Our Ref: B21454/FRA

Date: 6th April 2017

RE: THONGSBRIDGE MILLS, MIRY LANE, THONGSBRIDGE, HD9 7RW

I refer to the comments made by Paul Farndale on the Flood Risk Assessment report by jnp group submitted with the outline application for this site.

Culvert Plan

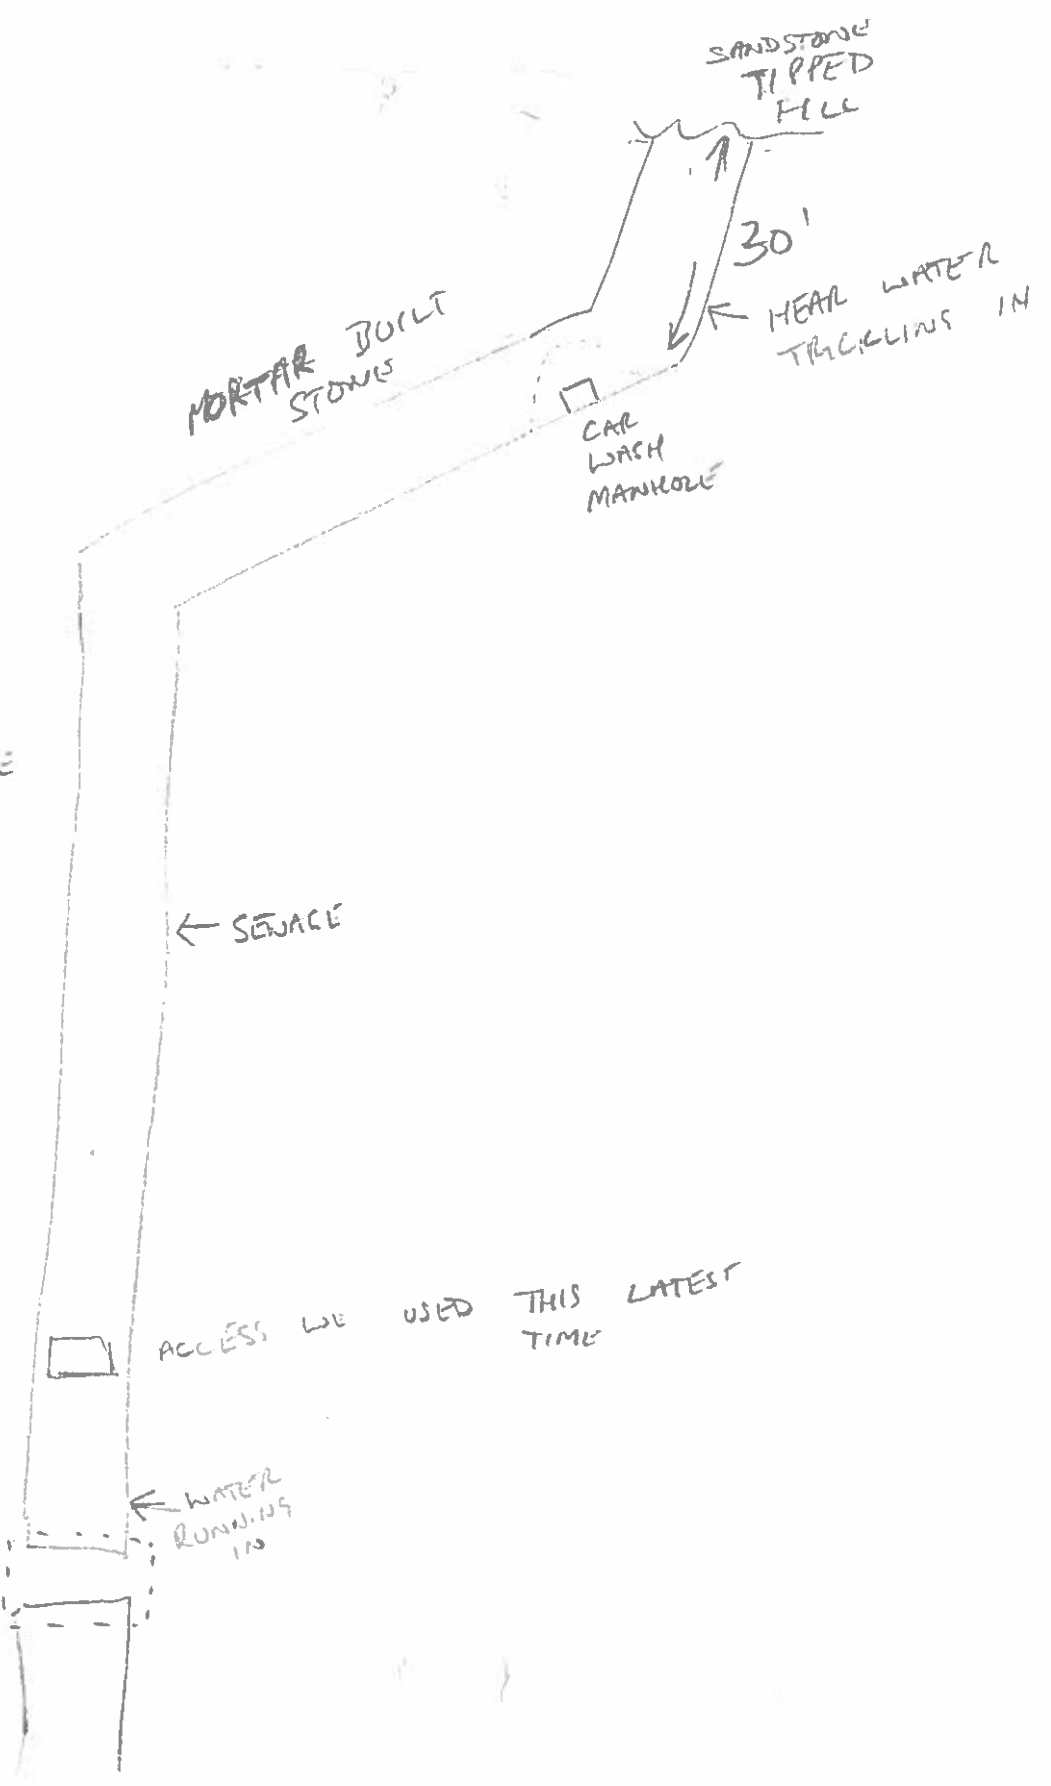
We do not object to direct connections of 5l/s/ha for the developed area to watercourse. Indirect connections via culvert can only be permitted if the said culvert is desilted and demonstrated as 'fit for purpose'.

Appropriate stand-off distances to culverted watercourses need to be established based on size, depth and condition currently not provided.

It is proposed to discharge surface water to the River Holme via the culvert to the north east of the site, a distance of approximately 25m. The culvert will be inspected and desilted, if the condition is found to be unsuitable for the discharge of surface water directly through the culvert, a pipe will be laid through the culvert.

The culvert commences at the eastern edge of the site and does not underlie the site, therefore a stand-off distance is not required. The land to the north east is owned by the client (Mr Marsden) and he has indicated that routing the surface water through this culvert is acceptable.
